City of Albuquerque

RE: HAMILTON TEST FACILITY DRAINAGE PLAN DATED 6/18/82
(FILE NO. J14-D21)

AS-BUILT DECEMBER 13, 1982 AS-BUILT GRADES IN PARENTHESES ONLY		DRAINAGE PLAN HAMILTON TEST SYSTEMS VEHICLE INSPECTION PROGRAM ALBUQUERQUE, NEW MEXICO		332309
SP-6		FLETCHER-THOMPSON INC. ARCHITECTS / ENGINEERS BRIDGEPORT, CONNECTICUT		SP-6

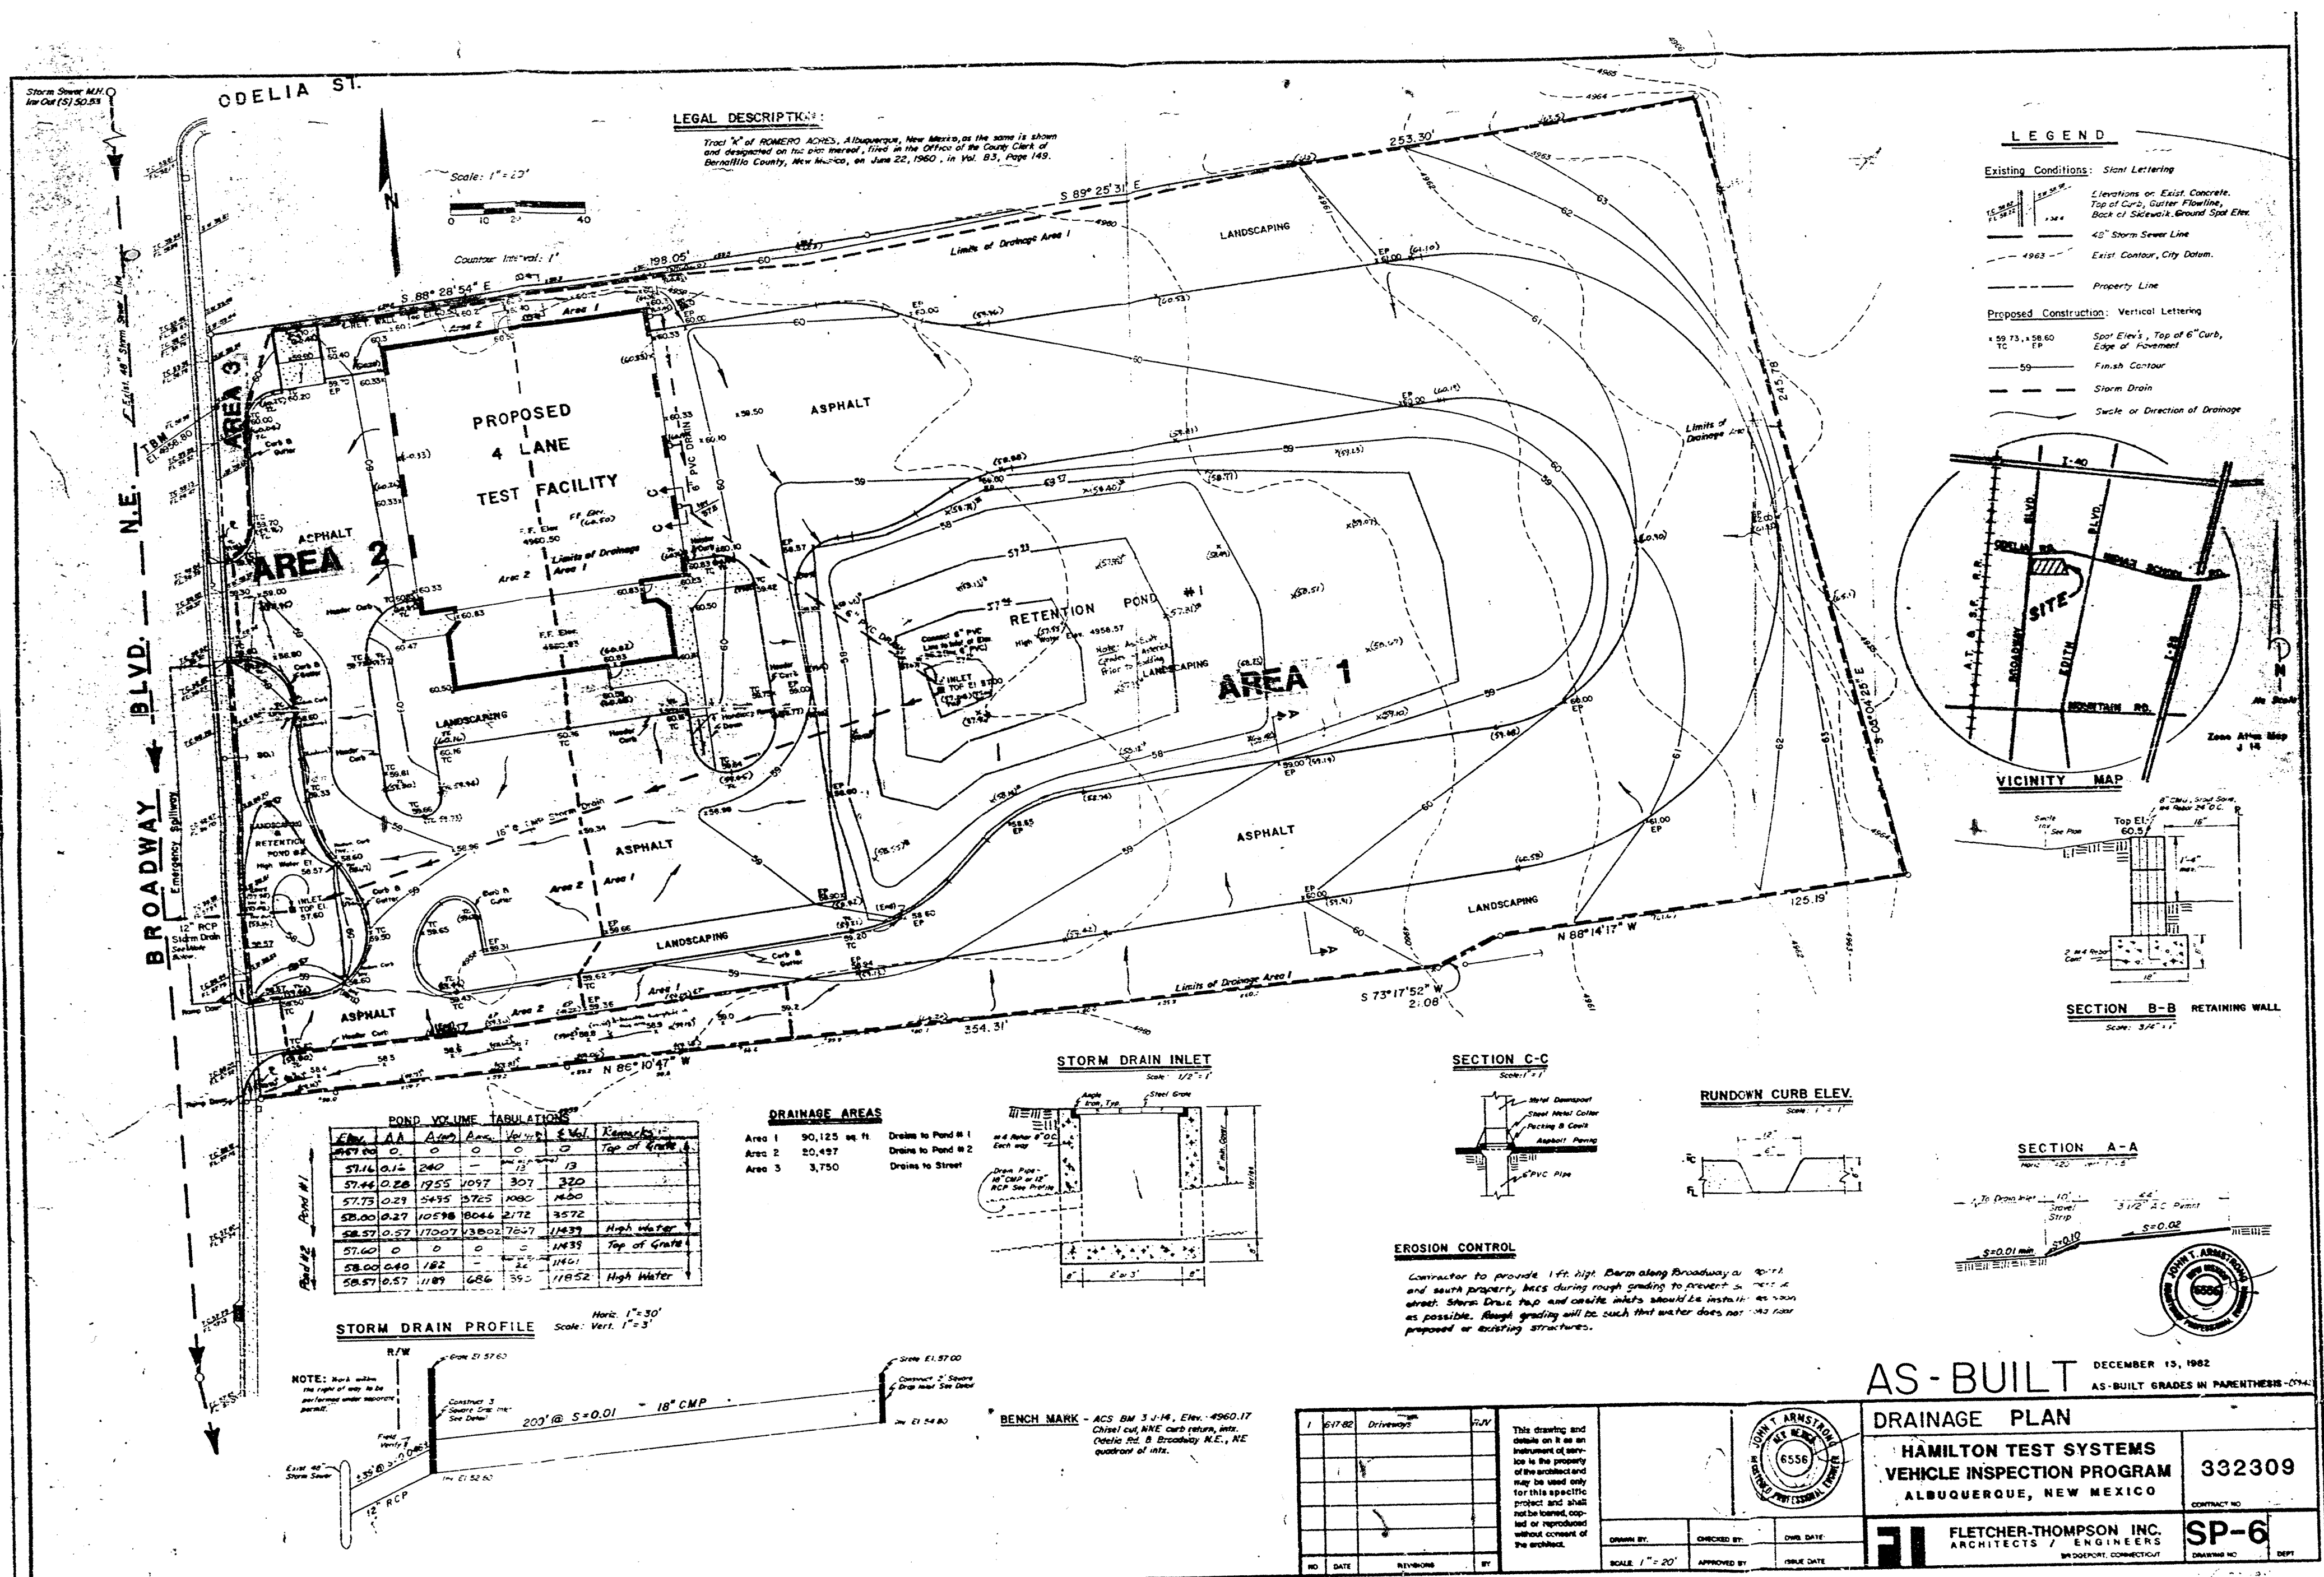
17. Proposed Treatment - adequate treatment of on-site flows including:
 - A. Definition of required drainage facilities.
 1. Pond volume calculations including routing if applicable.

- B. Legal description or current plat.
24. Proposed Conditions:
 - D. Internal contributory drainage areas, including roof areas, outlined on plan.
 - H. Notes defining property line, asphalt sidewalks, planting areas, ponding areas, and all other areas whose definition would increase clarity. (show limits of curbs on-site).

- M. Details of ponds, swales, rundowns, curb cuts, water blocks, emergency spillways, retaining walls, pond outlets, safety fences, cross-sections, spot elevations and supporting calculations when appropriate. All cross-sections must be drawn to standard engineering scale or adequately dimensioned. (Provide more detail of the 6" P.V.C. roof drain pipe, i.e., how will it be constructed?)

- N. The following phases of development outlined and numbered in sequential order of construction with a proposed erosion plan (see Erosion Control Plan Checklist)
 - 3. Construction phase
- P. Proposed construction of private storm drain improvements within the City right-of-way. (Office not required on-site per the City's Hydrology Engineer).
